**Re: R/225/17/CLE Lawful development certificate for an existing summer house.**

I write in respect of the above referred application for Lawful Development Certificate by Mr A Smith [the Applicant], the owner of Minstrels, 6 West Mead, East Preston, BN16 2SL [Minstrels]. We are the owners of 5 West Mead, East Preston, BN16 2SL [5 West Mead]. 5 West Mead shares a boundary with Minstrels.

**Please accept this submission as an objection to the Application.**

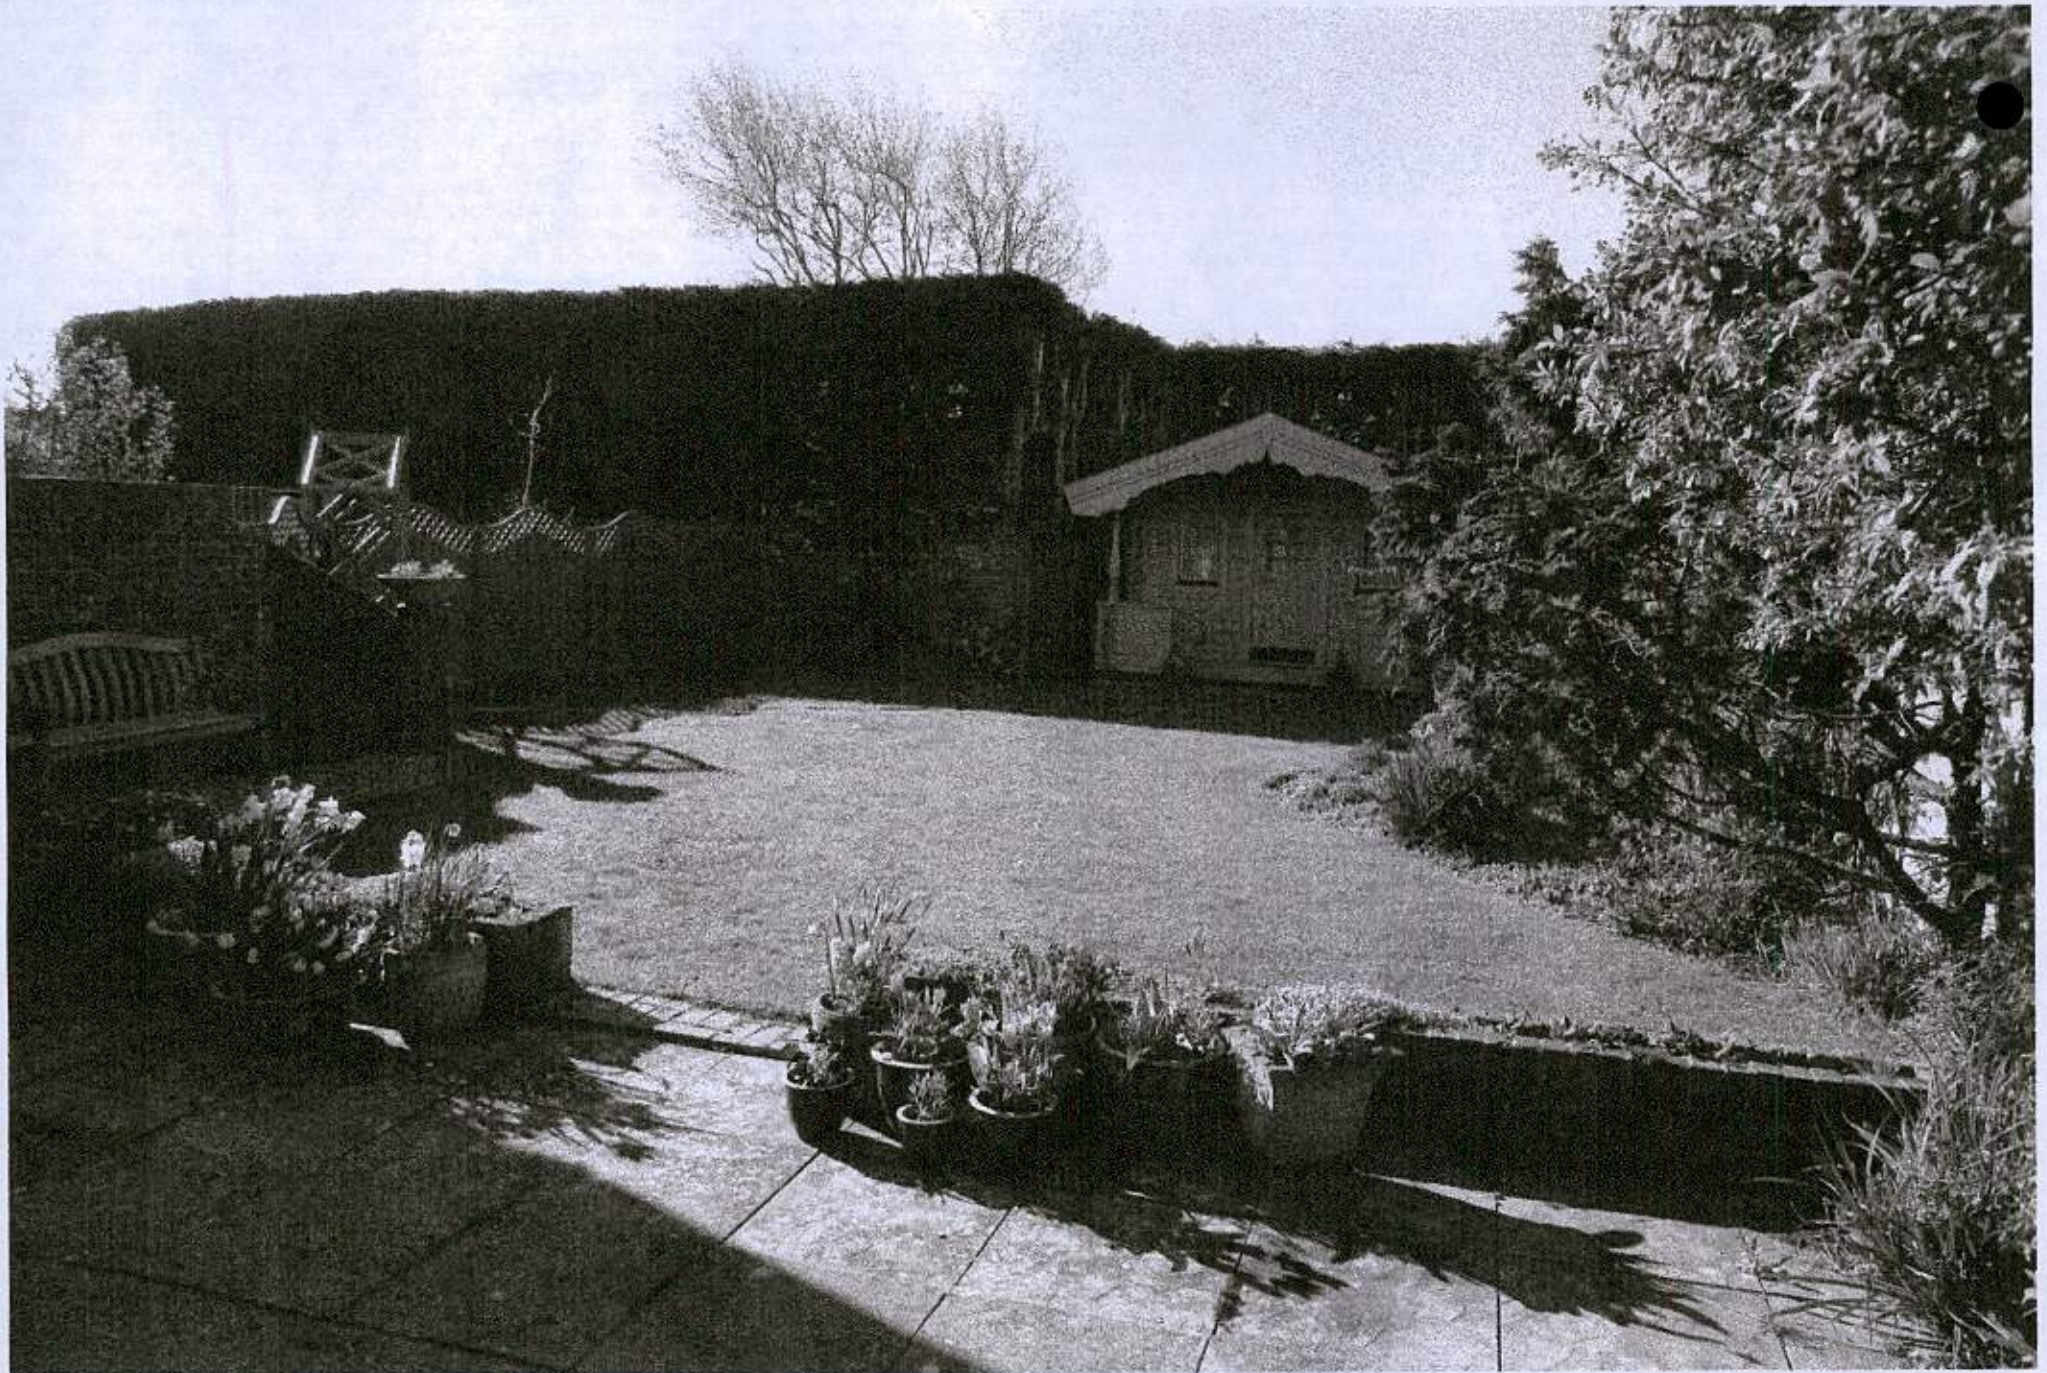
The Applicant ticks the box beside *'the use began more than 10 years before the date of this application'*. The Application Form is dated 9 October 2017. There are 'handwritten' dates of 25 October 2007 & 26 October 2007 on 2 photographs submitted in support of the Application which only show the foundation and base of the wooden structure. Assuming that those dates are accurate (although we have seen no evidence to verify the dates) it would not have been possible to effectively 'use' the wooden structure more than 10 years before the date of this Application.

There is no material evidence produced with the Application to support that the foundations and base of the wooden structure were created 10 years prior to 9 October 2017. There is only a handwritten date/month on the photographs.

Block Plan of Summer House

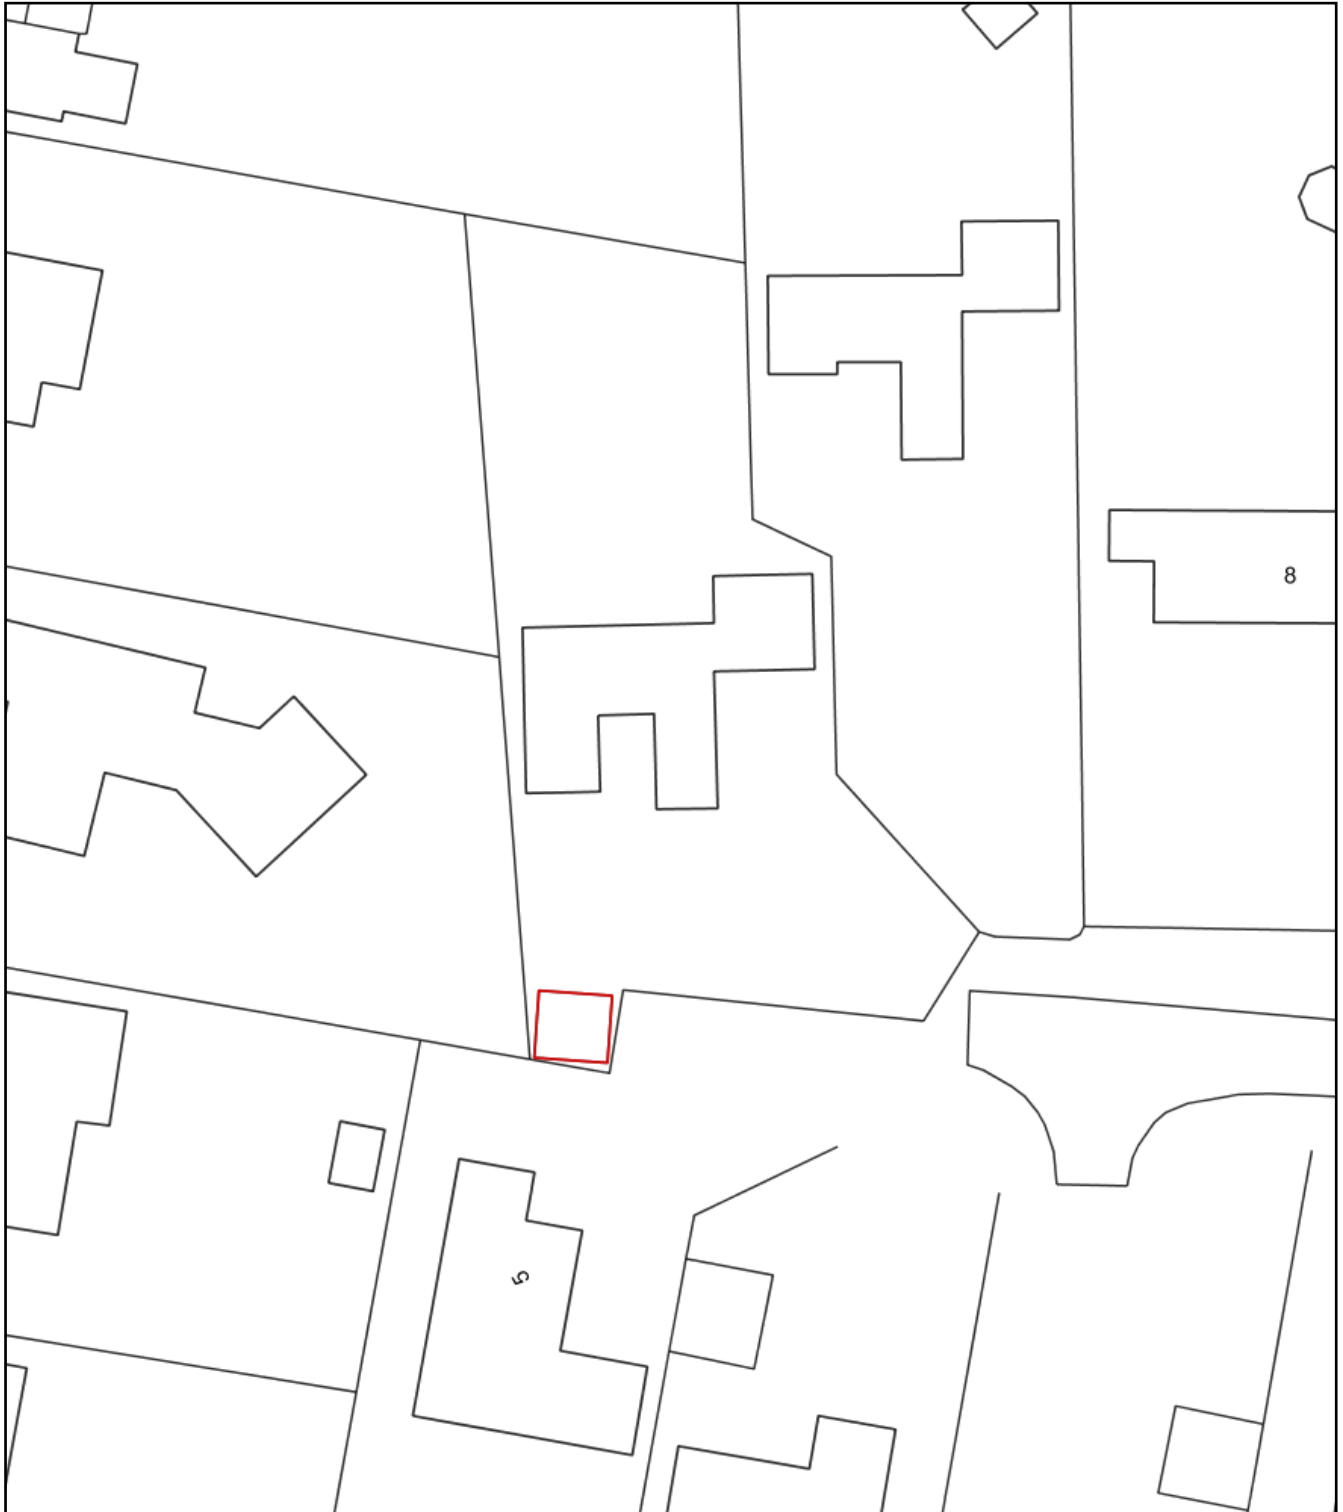
The block plan submitted by the Applicant in support of the Application shows that the south boundary with 5 West Mead, and directly behind the structure, as a straight line. This is not accurate.

We would also add that location plan submitted with the Application is therefore also not accurate.

The block plan submitted in support of the Application does not show '*measurements from the proposal to the site boundaries*' which is a requirement under the letter dated 17<sup>th</sup> October 2017 from Arun District Council to the Applicant.

Further, the block plan does not indicate the number of trees surrounding the structure either on the Applicant's land or that of 5 West Mead. Historically there were Leylandii trees on 5 West Mead within the vicinity of the structure, however those were removed (as referred to further below) and since August 2017 we have planted new trees at 5 West Mead within the vicinity of the structure.

The structure is constructed from a highly combustible material (wood) and within the structure there is an electrical supply. Its rear, left and right sides sit inches from wooden fencing. From the block drawing the structure is shown to sit tightly in an enclosed area with only the structure's front view and roof enjoying open space. We are therefore concerned about the *potential* spread of fire in this enclosed tight space.
